# OXFORDSHIRE COUNTY COUNCIL'S RESPONSE TO CONSULTATION ON THE FOLLOWING DEVELOPMENT PROPOSAL

**Application no:** 23/00170/REM

**Proposal:** Reserved Matters Application pursuant to Outline planning permission 14/02121/OUT for infrastructure comprising two junctions to providing vehicular and pedestrian access into the site from Middleton Stoney Road and two initial sections of internal road.

**Location:** Proposed Himley Village North West Bicester, Middleton Stoney Road, Bicester

TITLE
MIDDLETON STONEY ROAD,
SECONDARY ROAD JUNCTION.
GENERAL ARRANGEMENT
SHEET 2

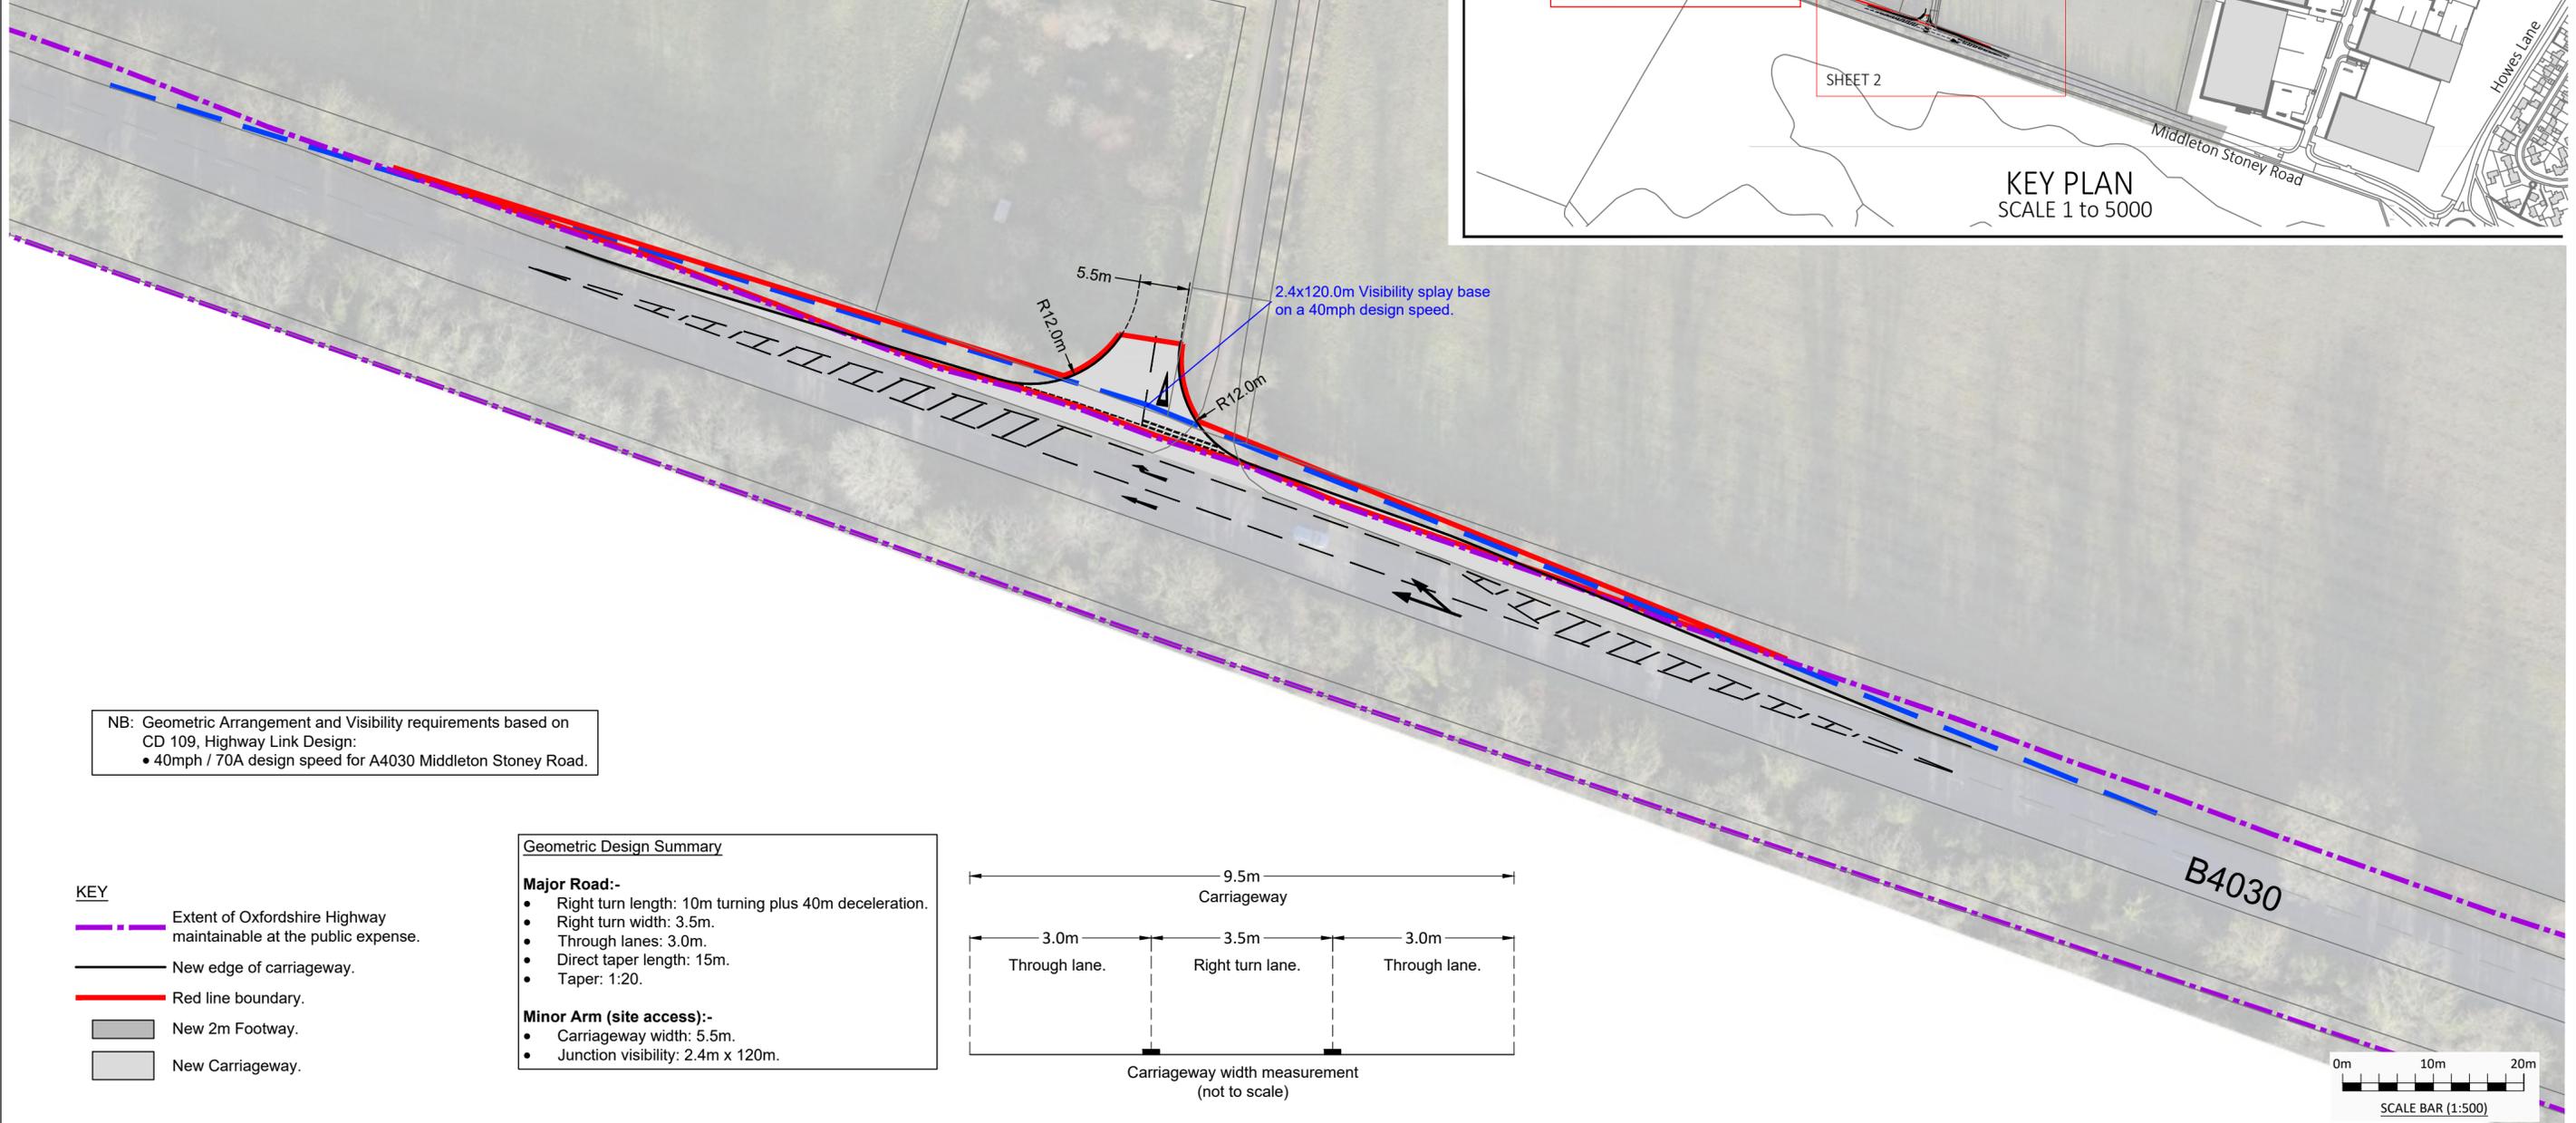
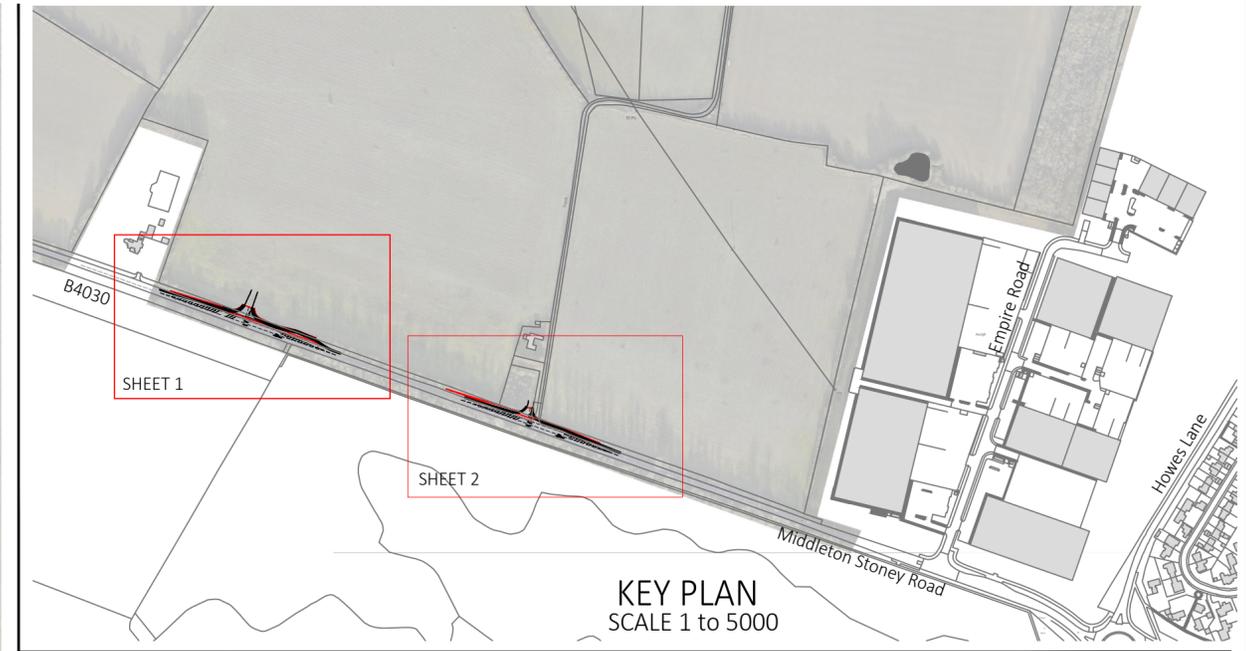
- The secondary access is insufficiently wide.

#### **Secondary road junction**

The same comments apply as for the spine road junction. However, the secondary road access must be a minimum of 6.5m wide to accommodate two-way bus movement, as it is expected that buses to/from Heyford Park will use both accesses in the future early stages of Himley Village development. A width of 5.5m is not acceptable and is a reason for objection.

TITLE MIDDLETON STONEY ROAD, MAIN SPINE ROAD JUNCTION. GENERAL ARRANGEMENT SHEET 1	
HYDROCK PROJECT NO. C-27141-C	SCALE @ A2 1 : 500
STATUS DESCRIPTION INFORMATION	STATUS S2
DRAWING NO. (PROJECT CODE-ORIGINATOR-ZONE-LEVEL-TYPE-ROLE-NUMBER) 27141-HYD-XX-XX-DR-D-0001	REVISION P01

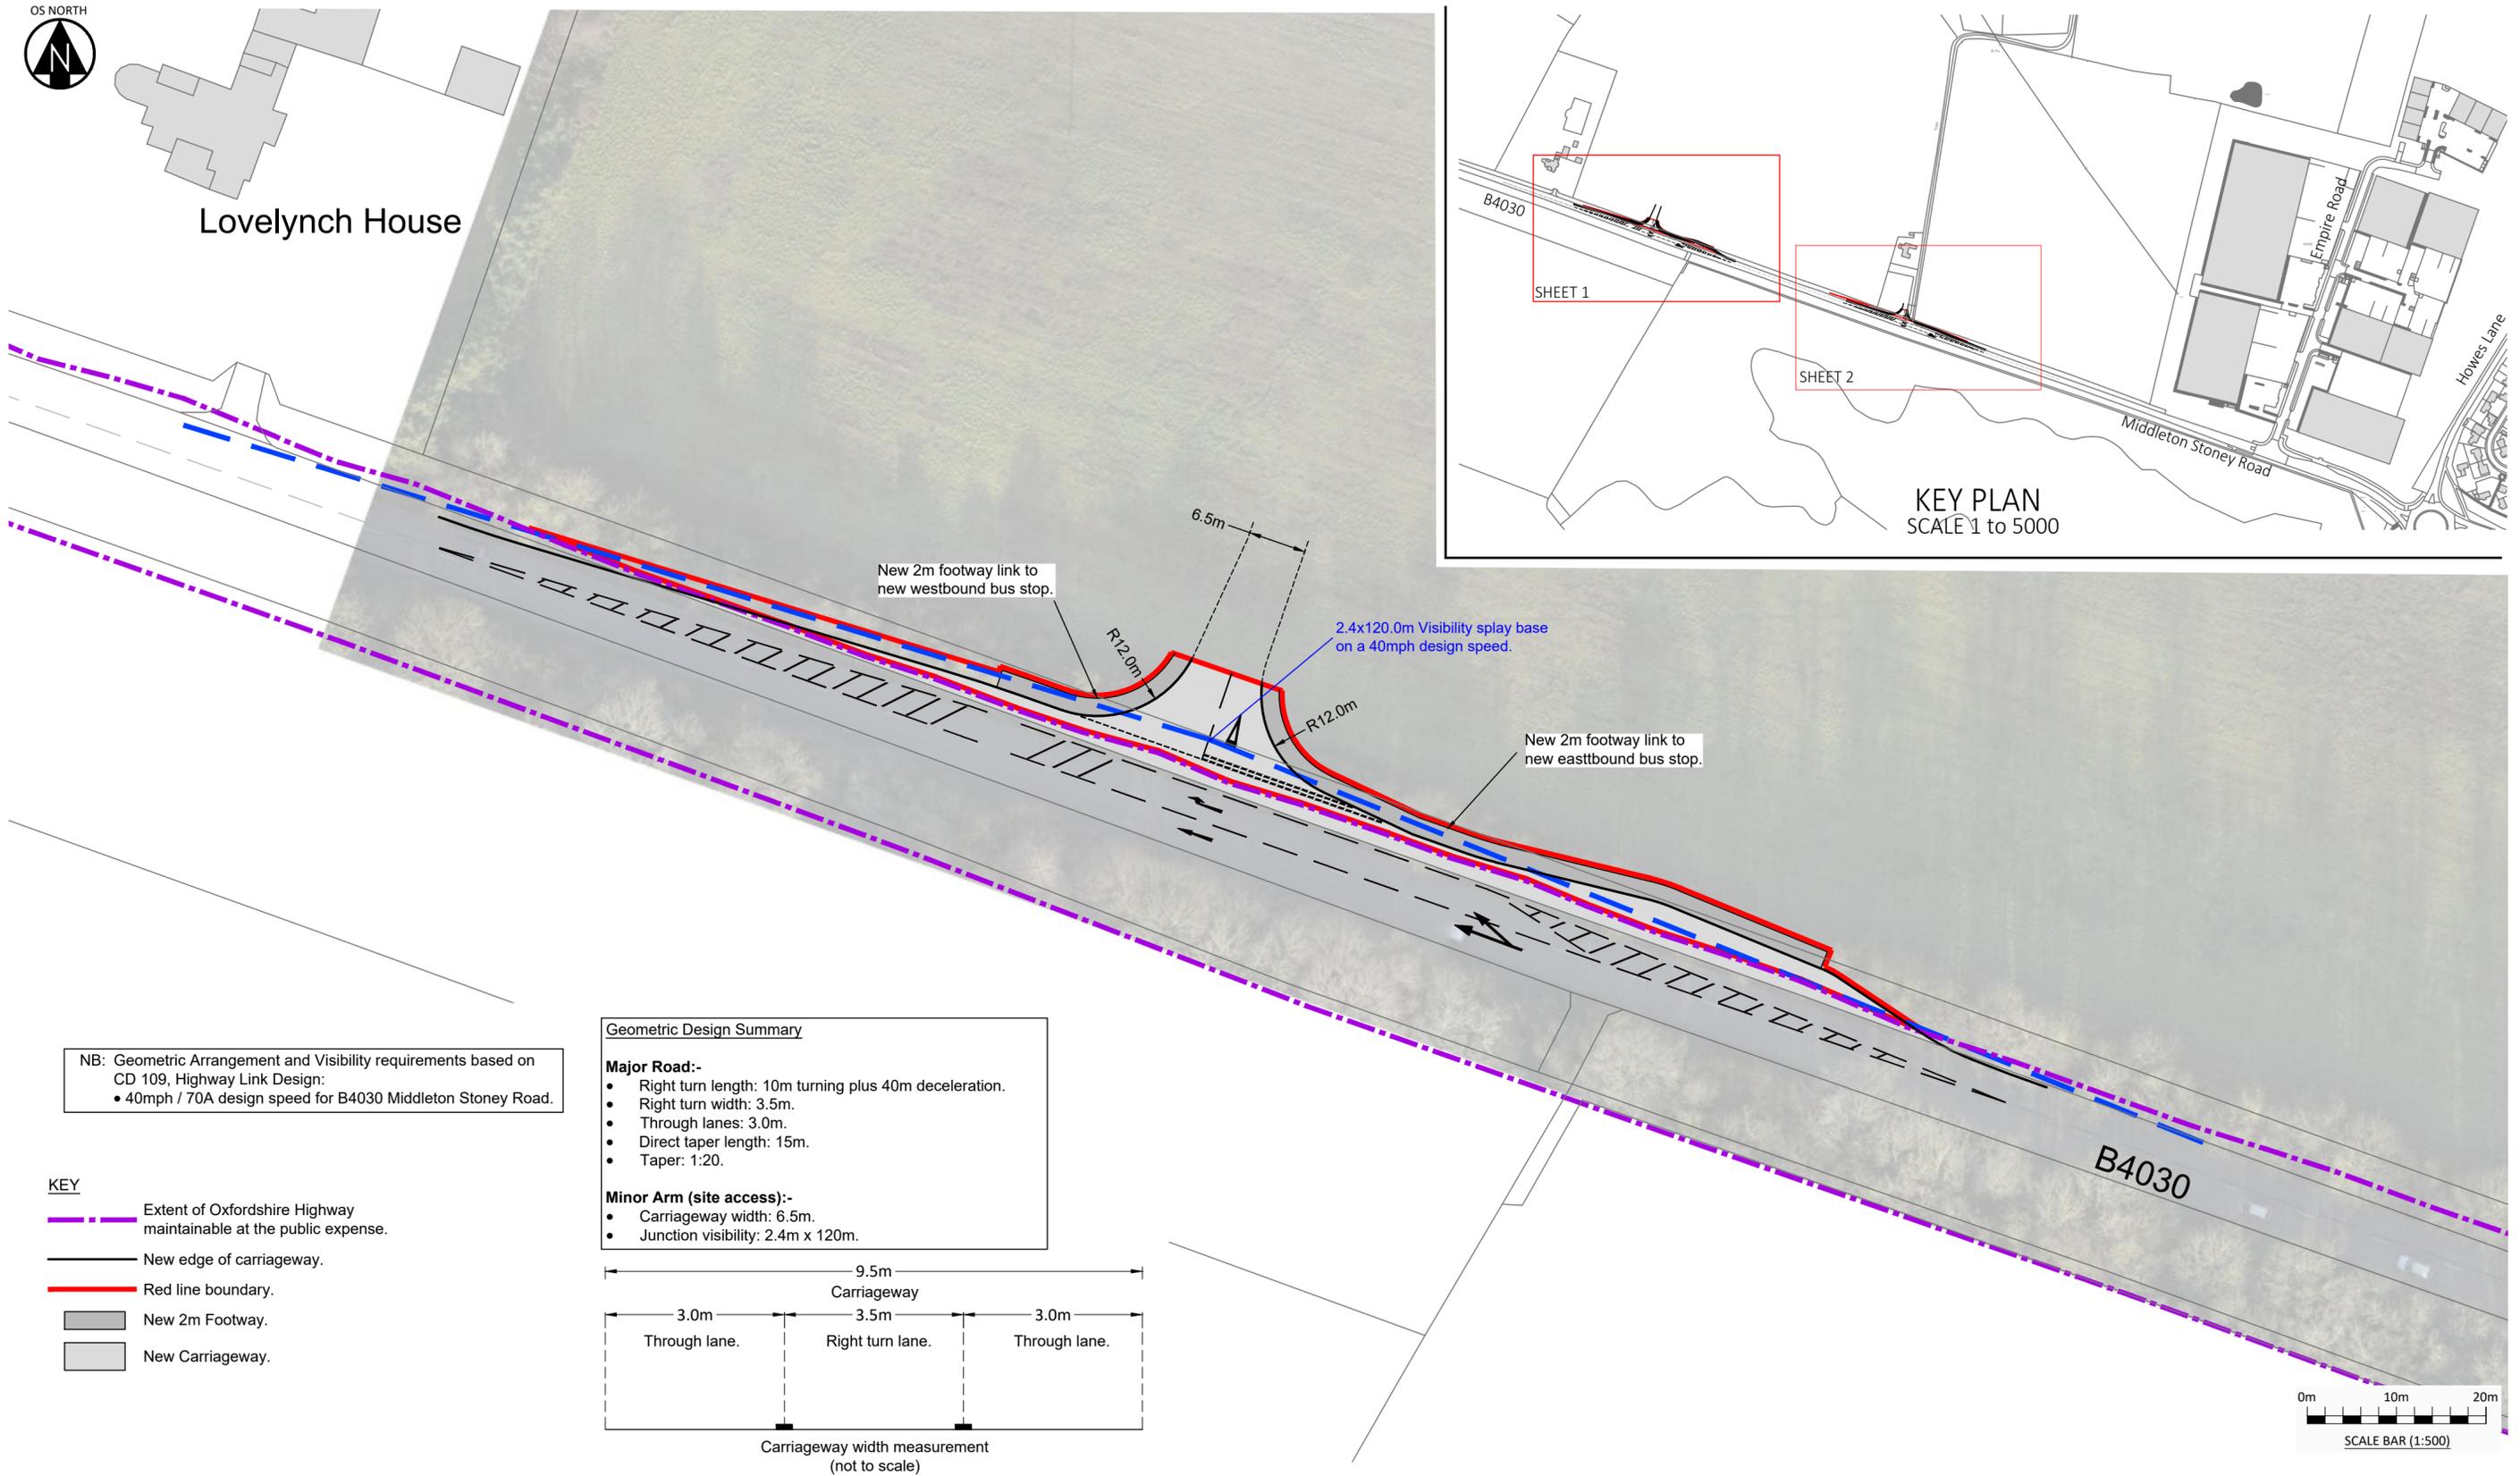
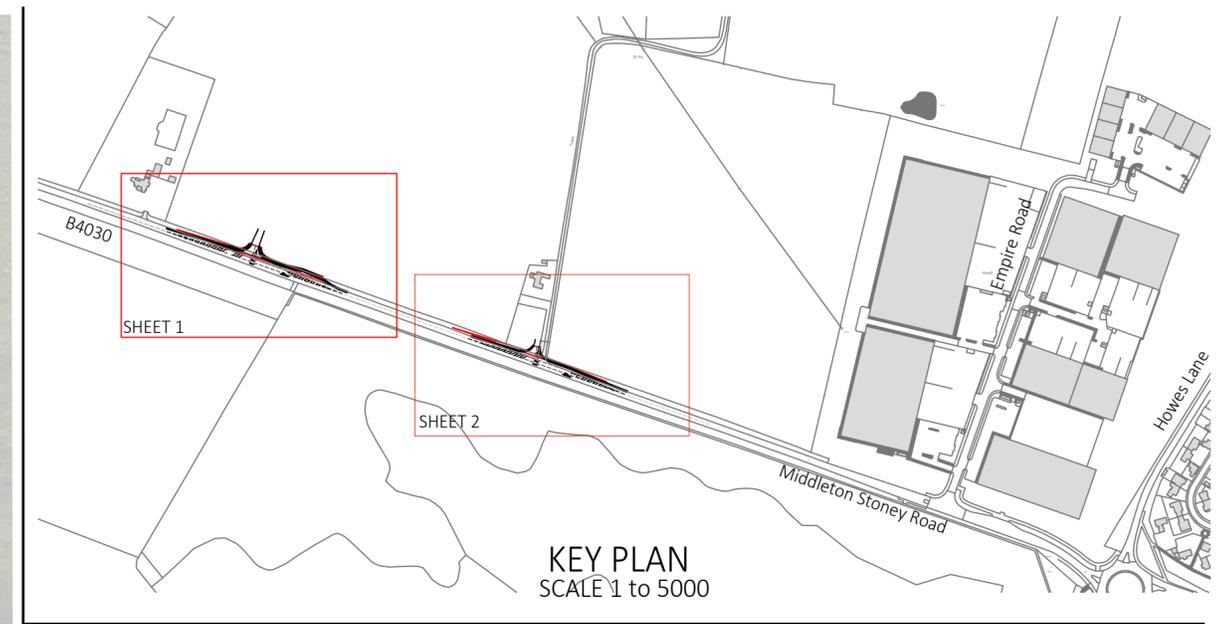
#### **Spine road junction**

Cycle facilities will be set back from Middleton Stoney Road, behind a swale, so do not enter into the red line area of this application.

Details of the access will be finalised during the technical approval process of the Section 278 application.
